Consultation Response from KC, Conservation & Design
2023/91531 Edgerton Villa, 22/24, Edgerton Road, Edgerton, Huddersfield, HD3 3AD
Listed Building Consent for alterations to convert offices to 7 flats (within a Conservation Area)
Date Responded: 14.12.2023
Responding Officer: Sue Brooks
Responding Ref: HUD 27/489

GROUND FLOOR PLAN
 24 Edgerton Road, Huddersfield. Scale 1:100
 ANTHONY DANN ASSOCIATES

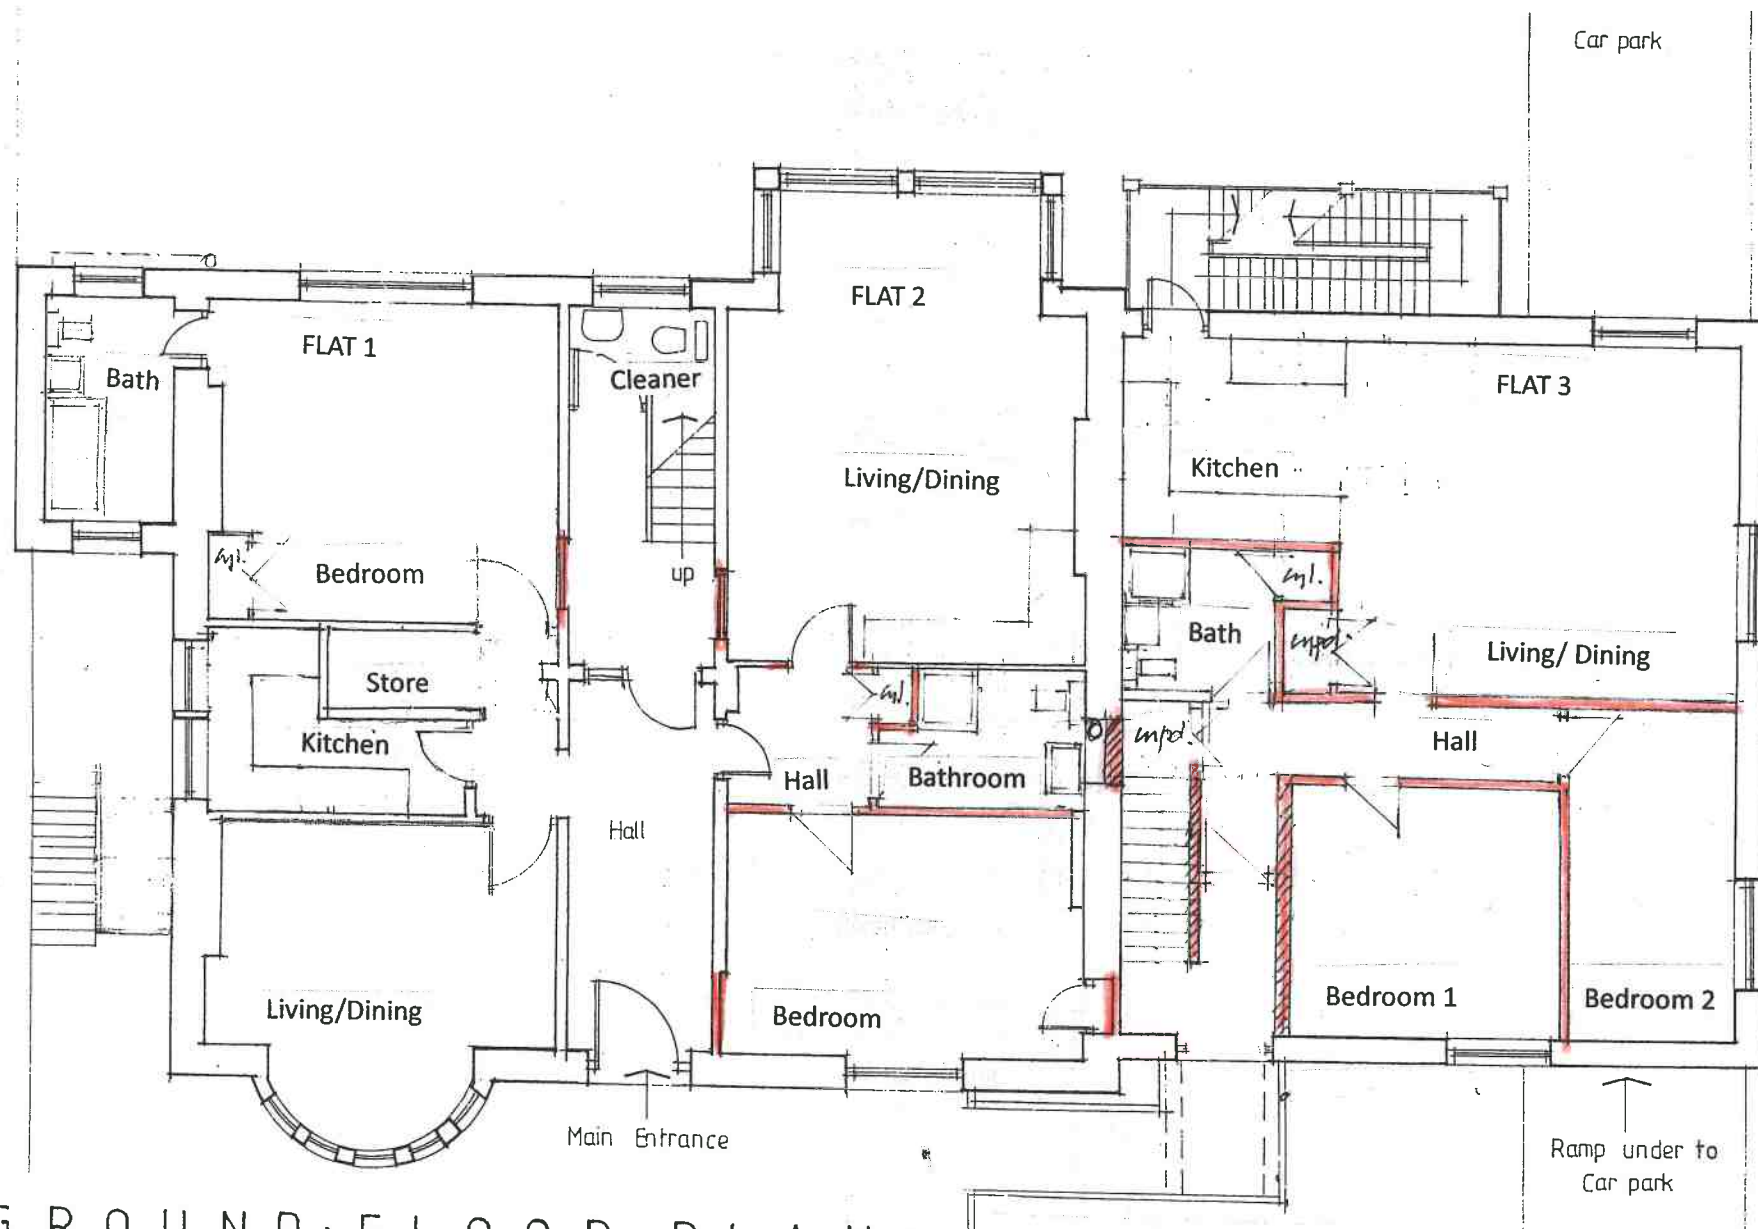
- A false ceiling is proposed below the covings to provide soundproofing and fire protection. As the ceilings within this flat are not overly ornate, this is acceptable subject to the intervention being fixed carefully and fully reversible, with no damage to the architectural details such as covings. We recommend that a condition is applied accordingly.

- Living/ dining room – The ceiling in this room is ornate and must remain exposed, without a suspended ceiling installed below. The applicant confirmed that this will be retained, with an intumescent paint treatment applied to achieve the necessary fire protection. We recommend that a condition is applied requiring details to be submitted for approval.

- Flat 1 ceiling - false ceilings installed within flat 1 shall be fixed carefully to avoid damage to the architectural details including covings and shall be fully reversible.

- Flat 2 ceiling - details of the intumescent paint treatment to the ceiling of the living/ dining room

in flat 2 shall be submitted for approval. Details shall include the finish, colour and texture.
